Cropredy Parish Council

APPLICATION No. 20/02060/F

PROPOSAL: Change of use of land to a mixed use for keeping horses (existing) and as a residential caravan site for 4 gypsy families, each with two caravans (including no more than 4 static vans (mobile homes) together with laying of hardcore.

LOCATION: The Stables, Main Street, Great Bourton OX17 1QU

# SITE LAYOUT PLAN

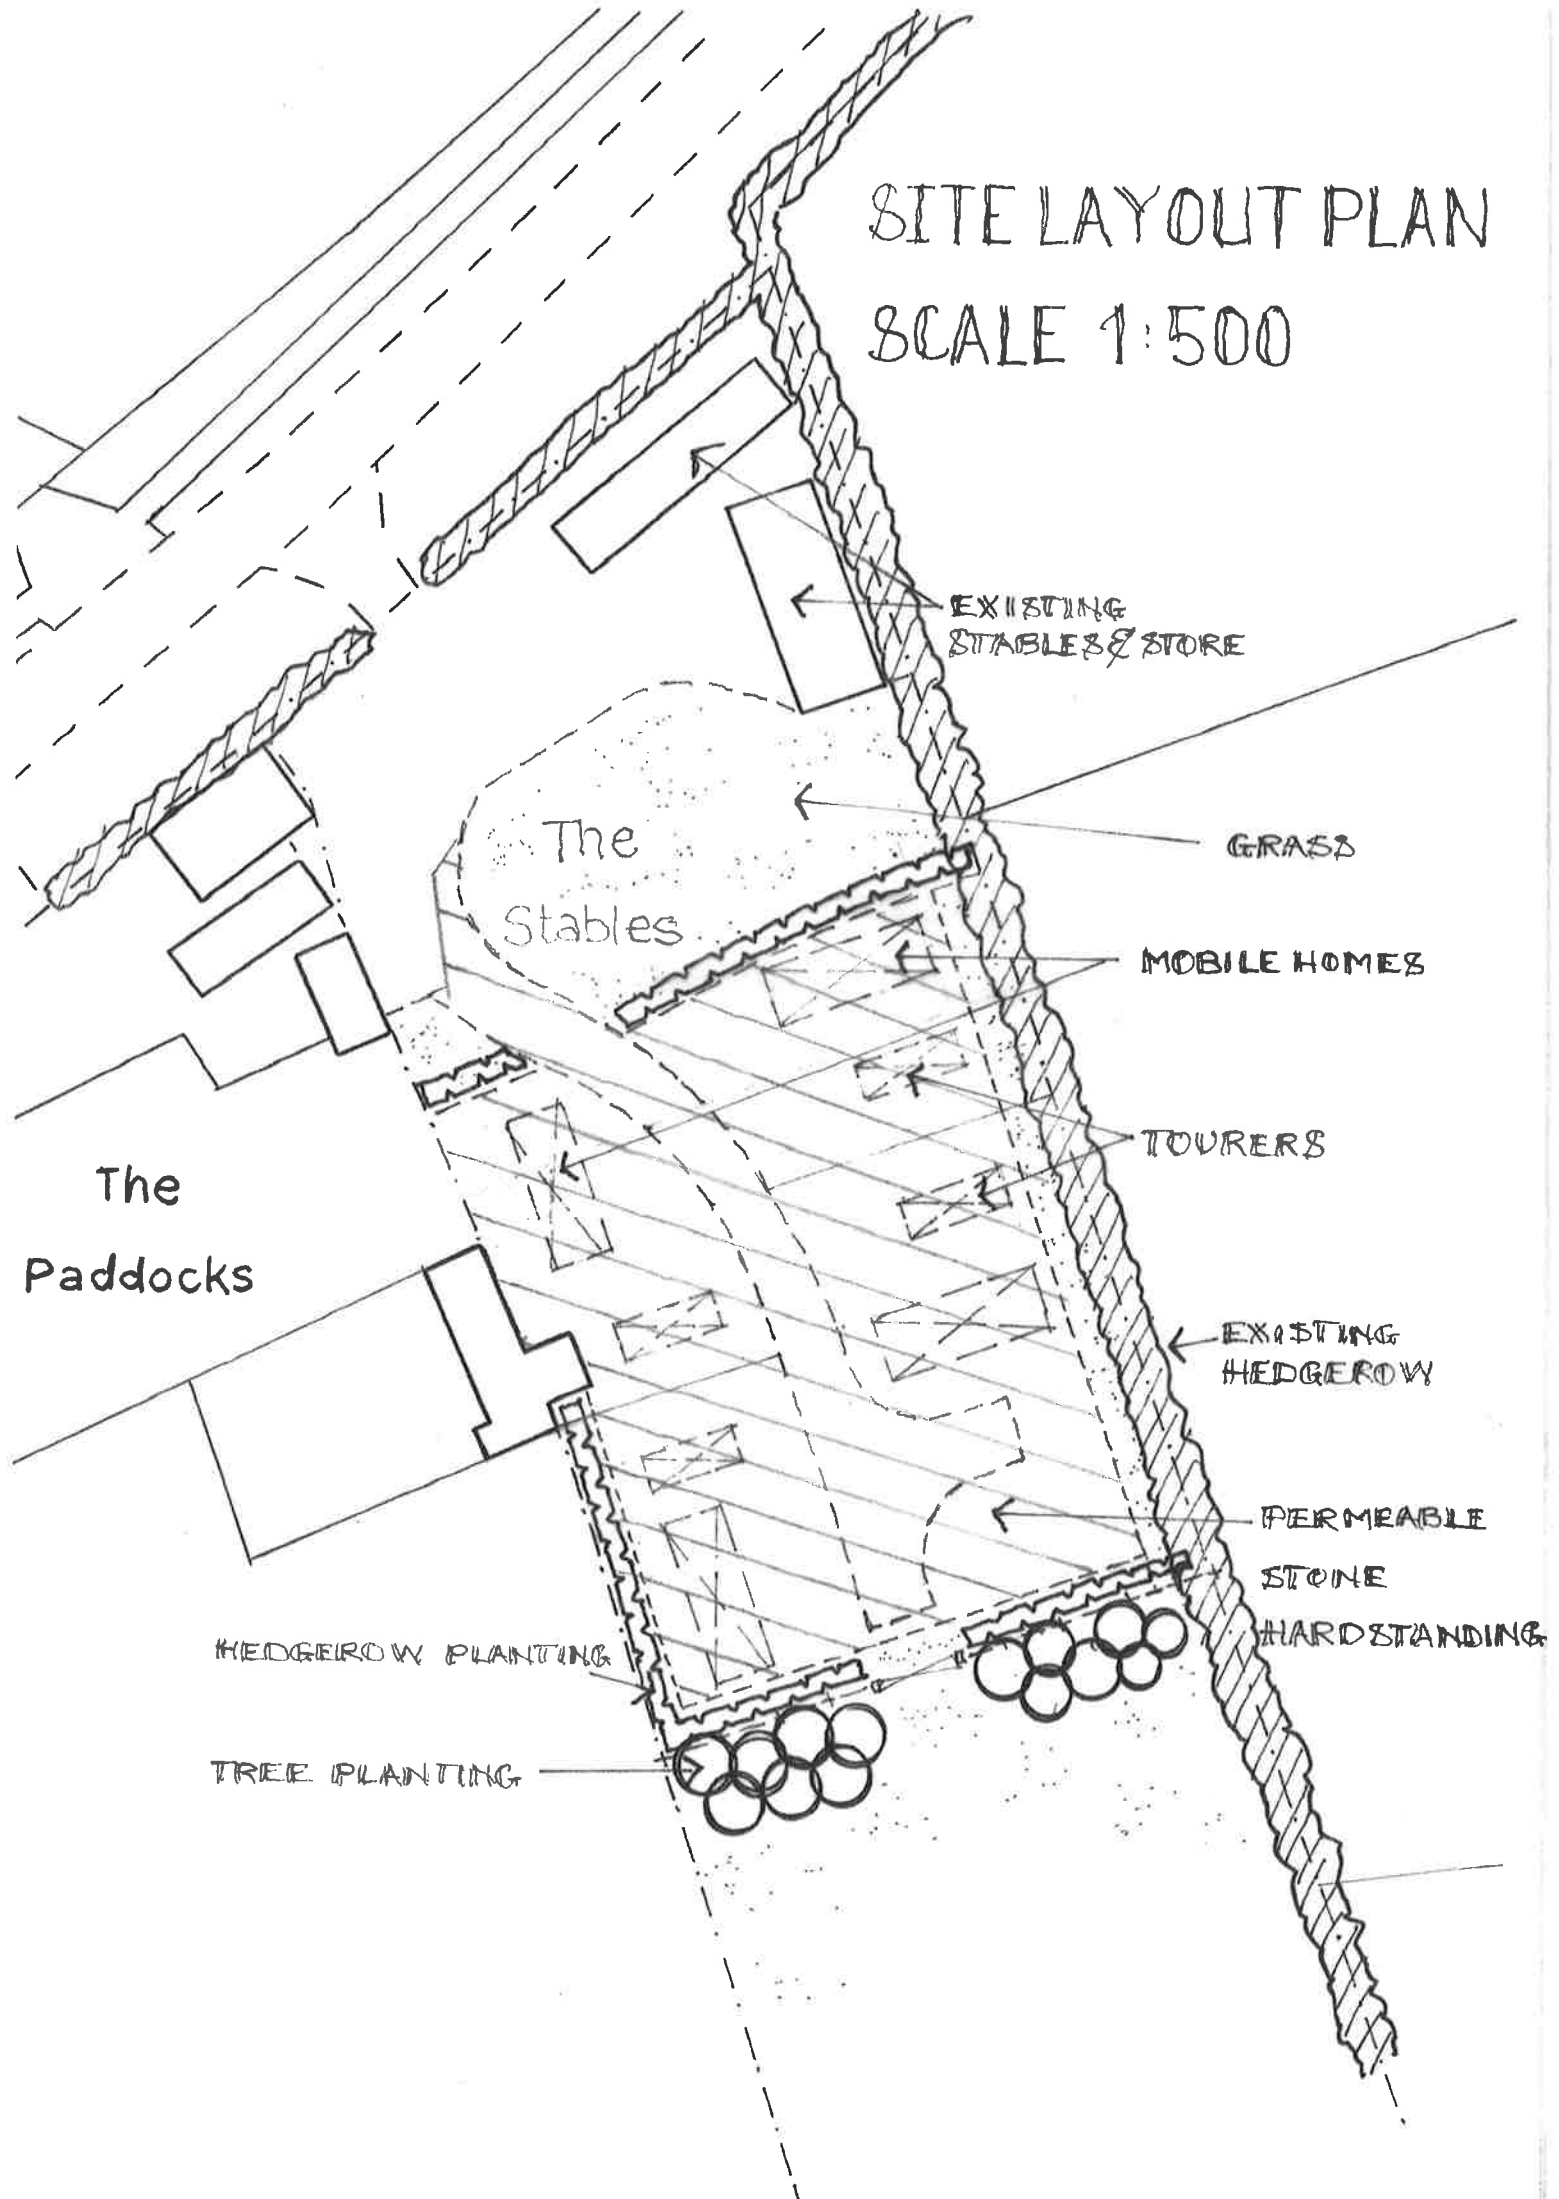
- Change of use from agricultural to residential: the area between the villages must be maintained
- Inadequacy of rural road for this type of vehicle
- Land already prone to flooding which would be exacerbated if hardcore laid down
- Historic ridge and furrow which will be destroyed by laying of hardcore
- This area is in Cherwell Local Plan as having high landscape value which will be destroyed by the development
- Application states no right of way through the land when there is a public footpath passing diagonally through.
